From: Charlotte Easton
Sent: 18 April 2019 17:09
To: Planning Scanning
Subject: FW: The Barn, 104 Felpham Road, Felpham - FP/43/19/L
Attachments: 1858 02 Plans Existing and Proposed 12 04 19.pdf; 1858 Heritage and Design Statement 12 04 19.pdf

Dear Charlotte Easton
The Barn, 104 Felpham Road, Felpham - FP/43/19/L

I write to you regarding The Barn, 104 Felpham Road, Felpham – reference FP/43/19/L, I am now the Planning Officer dealing with your application.

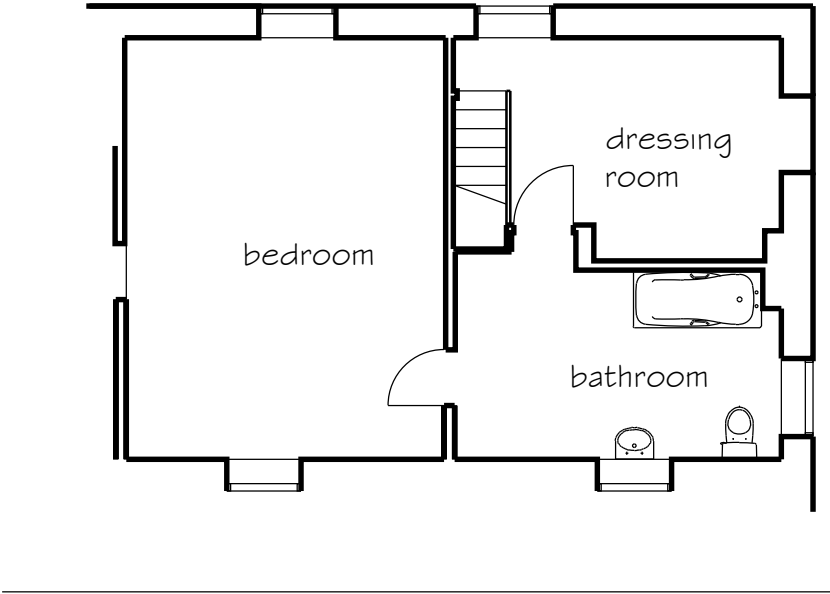
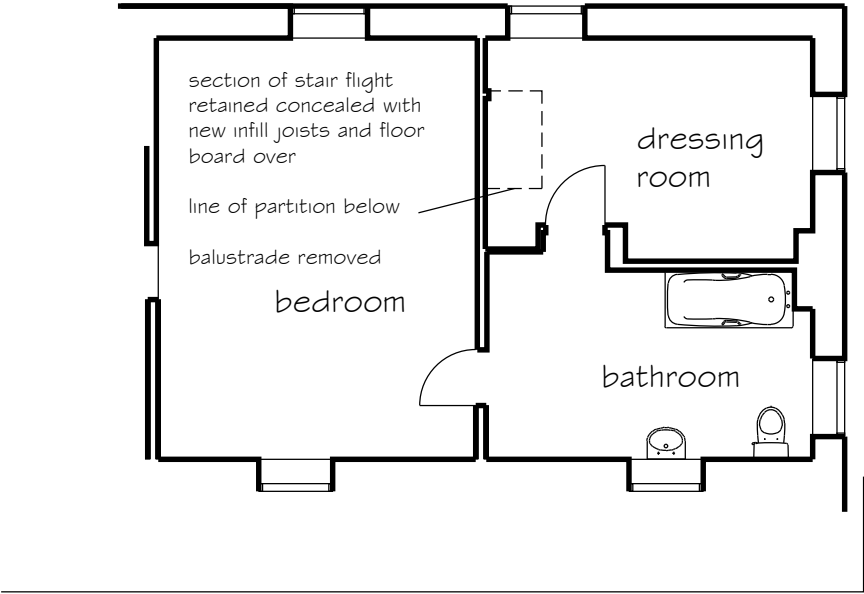
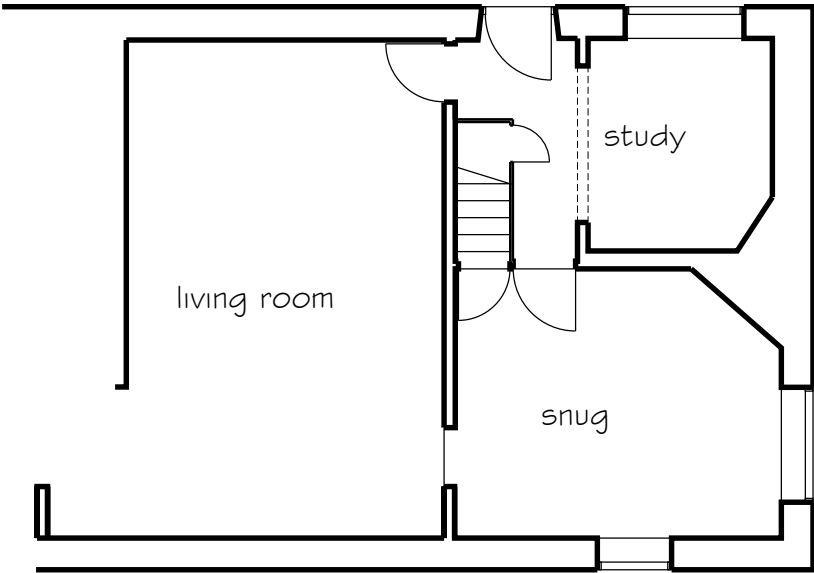
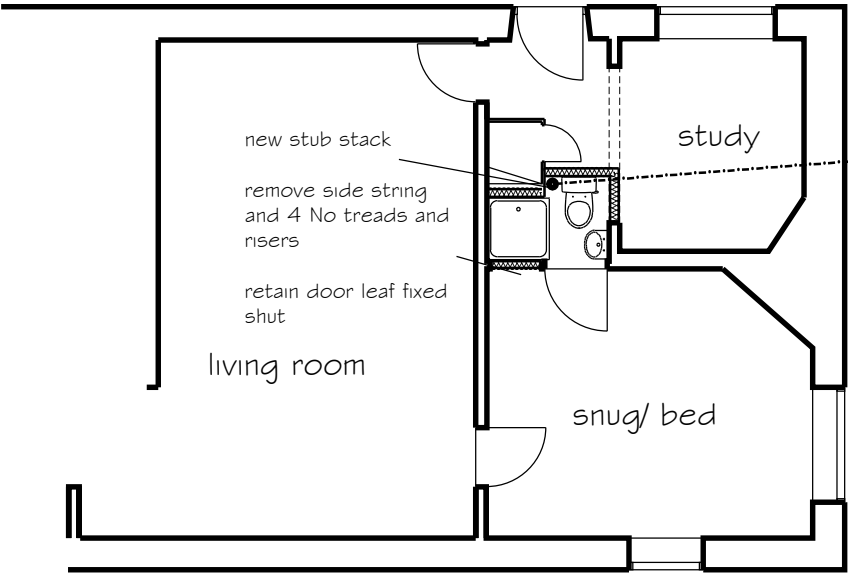
- a further in depth Heritage statement which includes details of the exact proposed works to the stairs and what the impacts will be to the existing dwelling and full justification of the proposed works.
- further details of the proposed stairs that are required are as follows, what impact will there be on the existing stairs? How does the applicant propose to enclose the stairs and keep the stairs in-keeping with the Listed building? Will the stairs be exposed or not and how will they be secured?
- Also, details on the extraction facilities of the proposed shower room.

We attach amended copy of our drawing 1858 P 02 Rev A incorporating the points discussed together with our supplementary Heritage statement expanding the content accordingly.
